Rezoning Transportation Analysis

Petition Number: 2023-012

From: Jake Carpenter, PE
Jacob.carpenter@charlottenc.gov
980-221-5675

Date	Description
5-24-23	First Review (PDM)
6-21-23	Second Review (DR)
8-23-23	Third Review (PDM)

REZONING
SITE PLAN

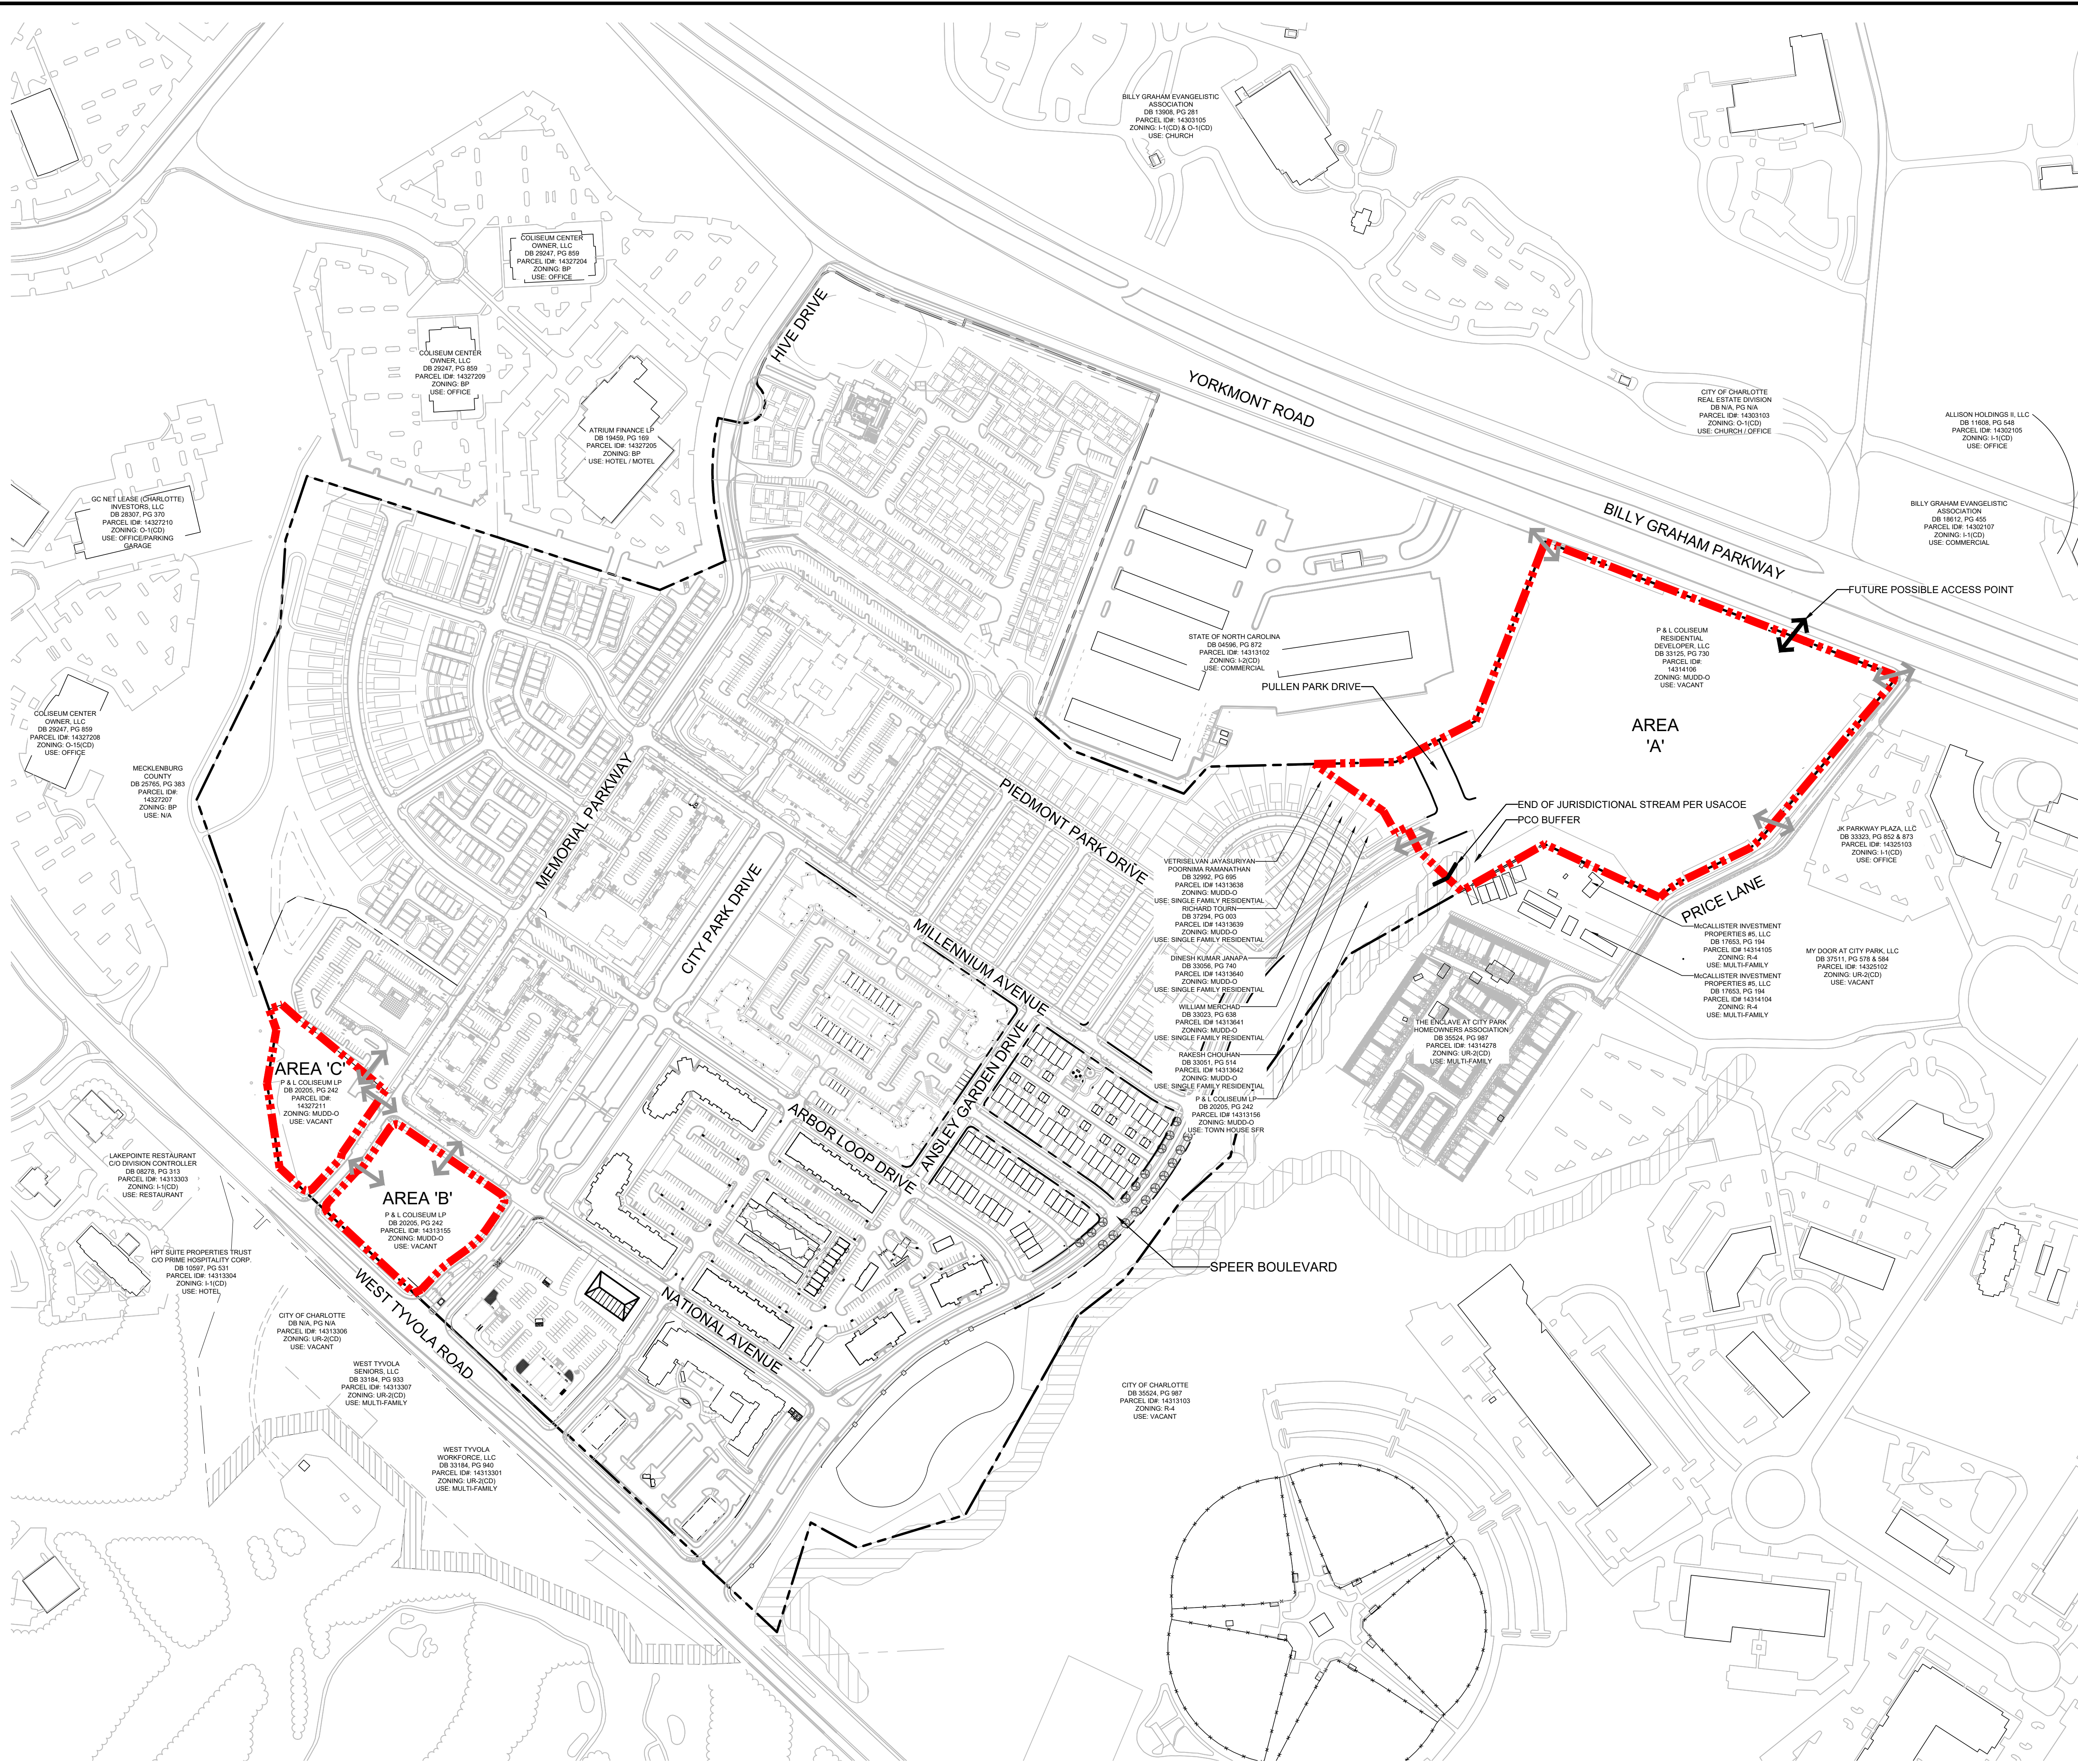
~~Label and dimension the curb and gutter from the centerline for each road on the site plan.~~

~~**Outstanding Comment from 6.21.23:** Label and dimension the curb and gutter from the centerline for each road on the site plan.~~

- ~~3. Revise site plan and conditional note(s) to commit to dedicate a minimum of 35 feet of right-of-way from the road centerline on Yorkmont Road and Speer Boulevard. The site plan shall label and dimension the right-of-way from the road centerline.~~

~~**Clarifying comment 6.21.2023:** Add conditional note to dedicate a minimum 35 feet of ROW from the roadway centerline of Yorkmont Road and Speer Boulevard. Additionally label and dimension.~~

Clarifying comment 6.21.2023: Add conditional note to provide 8 foot planting strip and 8 foot sidewalk along Yorkmont Road and Speer Boulevard. Additionally, revise to show 8 foot sidewalk.

Clarifying comment 6.21.2023: Add conditional note about ROW dedication to the City for possible future Speer connection to Billy Graham Parkway. Speer Road Stub needs to be extended to property line if it will not tie into Billy Graham Parkway.

ENLARGED  
SITE PLAN

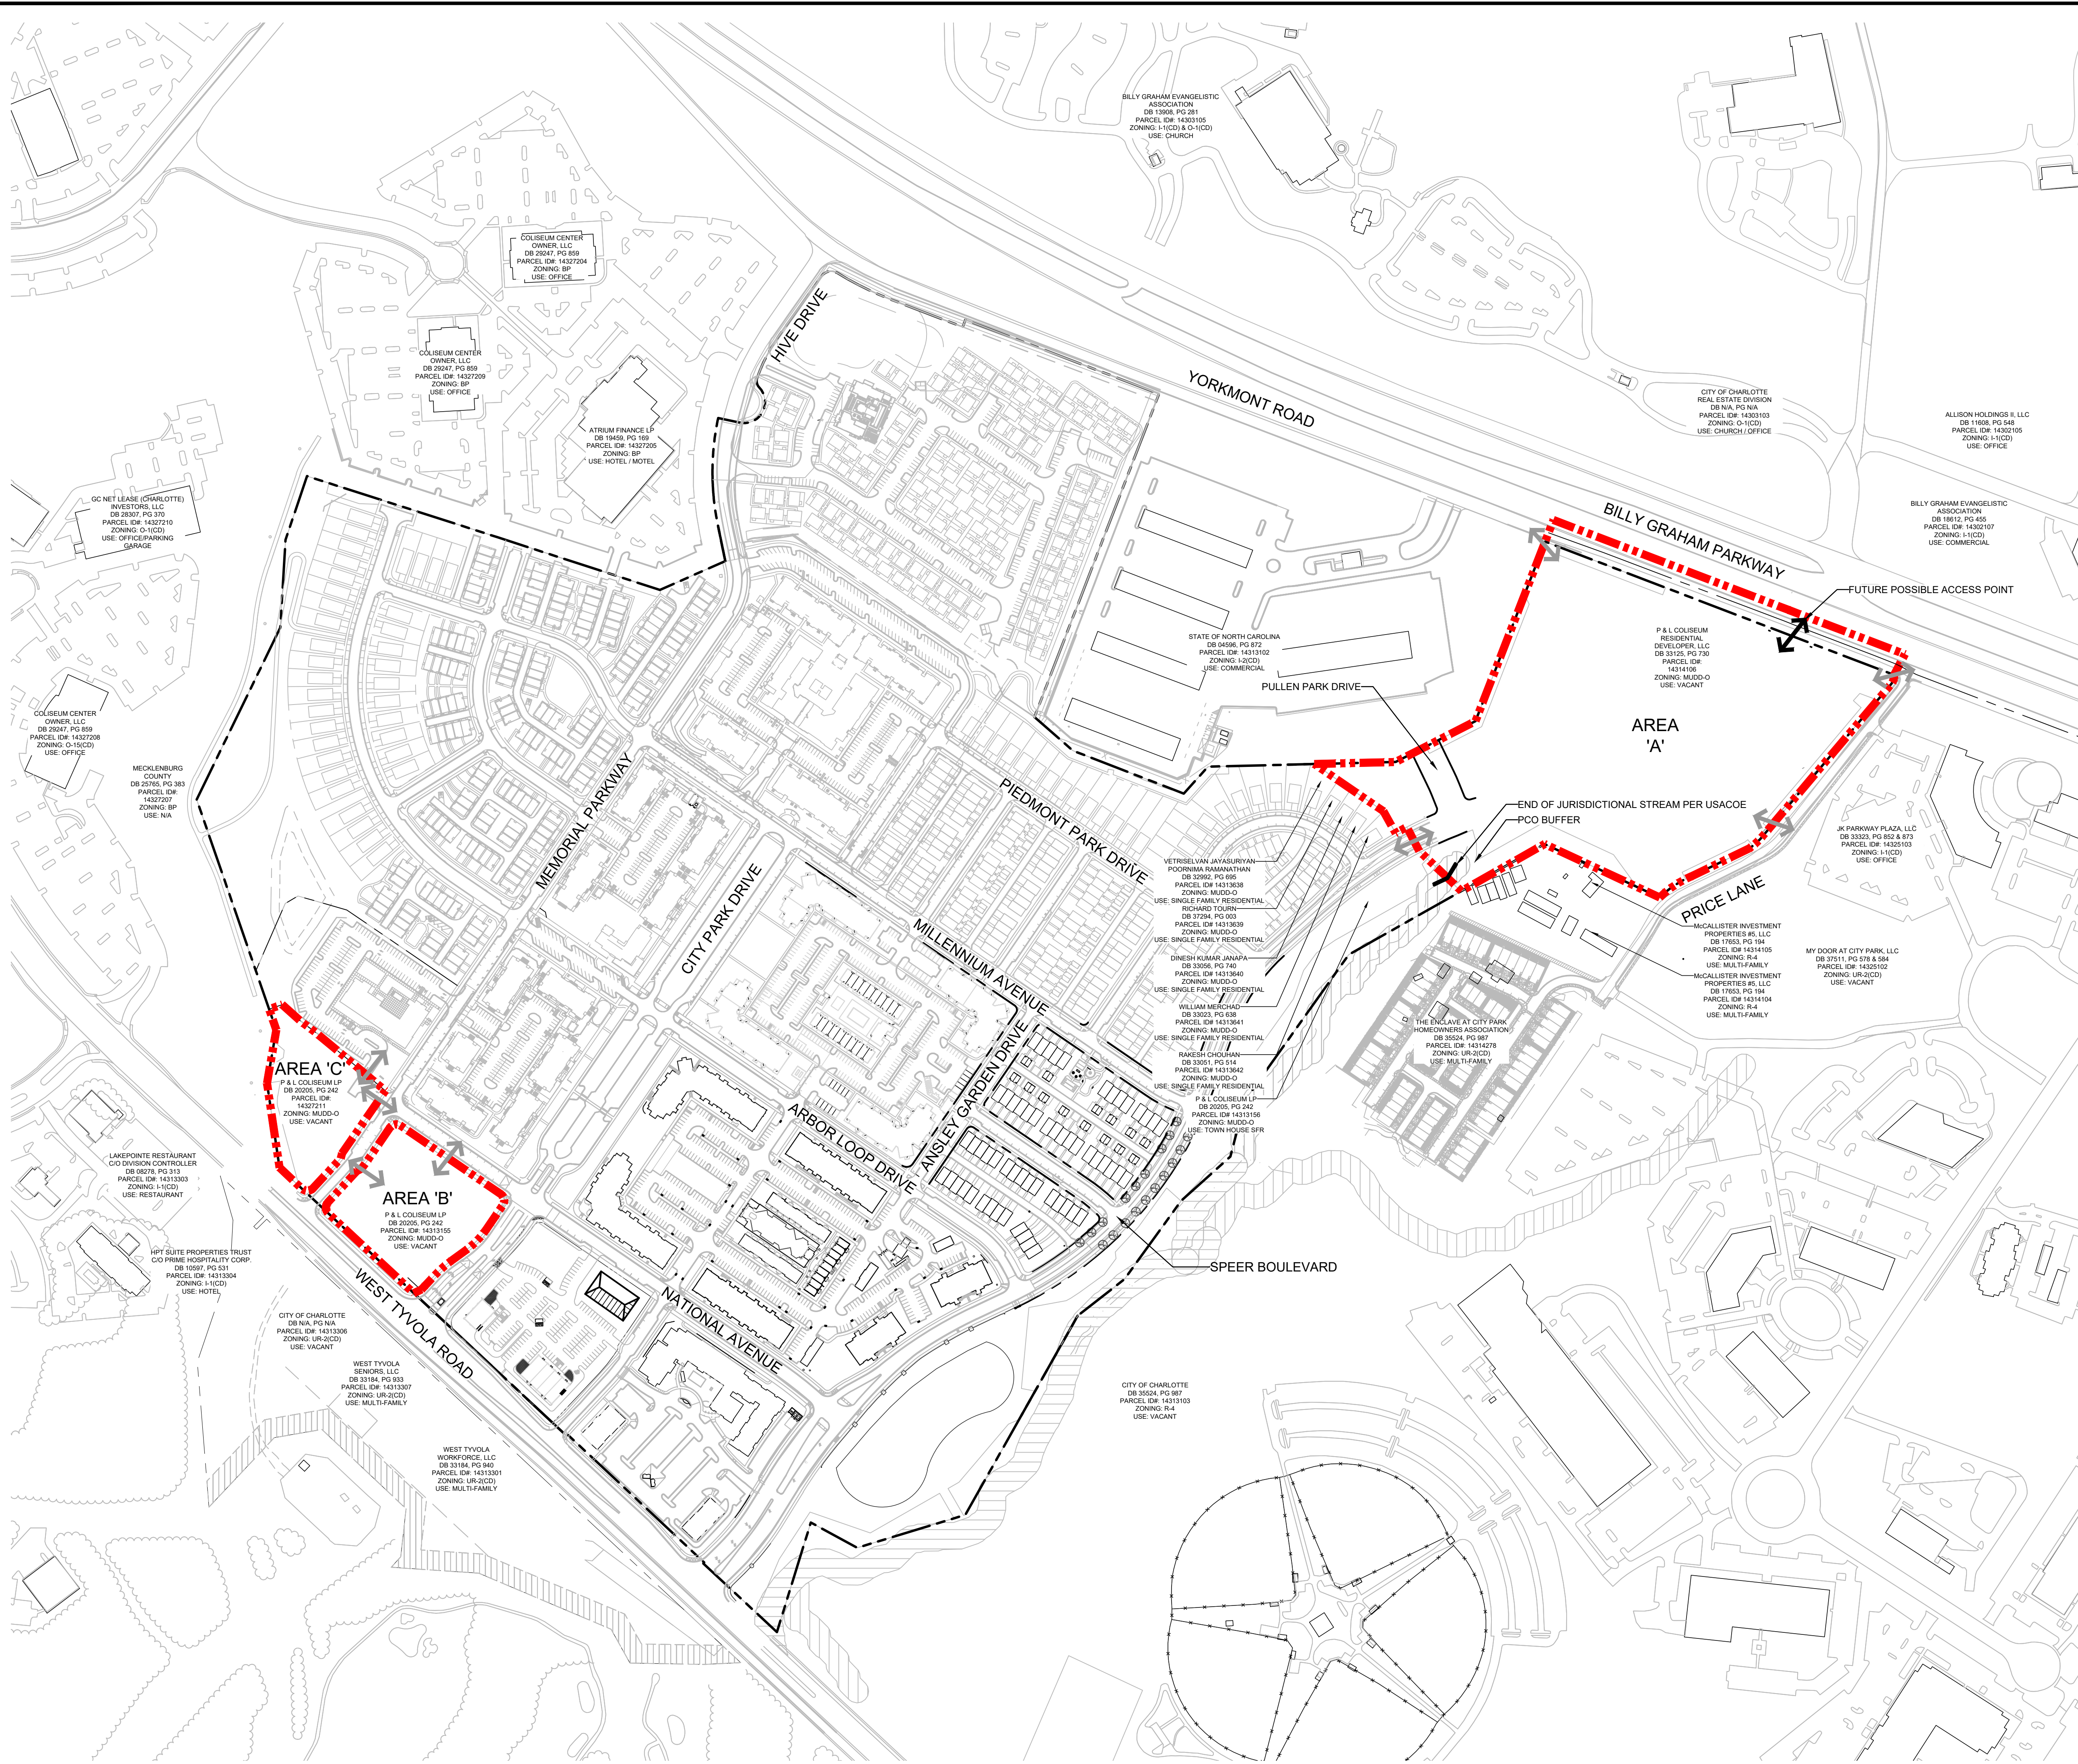
12. **Clarifying comment 8.23.2023:** Remove that the City of Charlotte to construct traffic signal and all other signal improvements at Tyvola and Speer. Developer to install traffic signal and all other related signal improvements at Tyvola and Speer prior to first CO of Developer Area A.

- b. Tyvola Road and Speer Boulevard:
 - City of Charlotte shall construction of a traffic signal at Tyvola Road and Speer Boulevard. If not completed by City by CO, then this condition shall be waived or delayed.

- Restripe the existing southbound striped out lane to have dual lefts on Speer Boulevard.
 - City of Charlotte shall implement Leading Pedestrian Interval+ (LPI+), Accessible Pedestrian Signals (APS), and right-turn Flashing Yellow Arrow (FYA) with LED blankout sign for the southbound right-turn lane on Speer Boulevard.

13. **Clarifying comment 8.23.2023:** Remove “existing curb ramps to remain”. All non-compliant ramps at South Tryon Street and Tyvola Road are to be upgraded as necessary.

- b. South Tryon Street and Tyvola Road:
 - Add pedestrian signals including associated work (striping, APS, LPI+ where right turn lanes are present) for all approaches. Existing ramps to remain.

14. **Clarifying comment 8.23.2023:** Remove note below.
 - b. In the event that Petitioner cannot obtain all approvals and permits required to construct the improvements set out above in the Development Standards, then Petitioner shall have no obligation to construct such improvements.
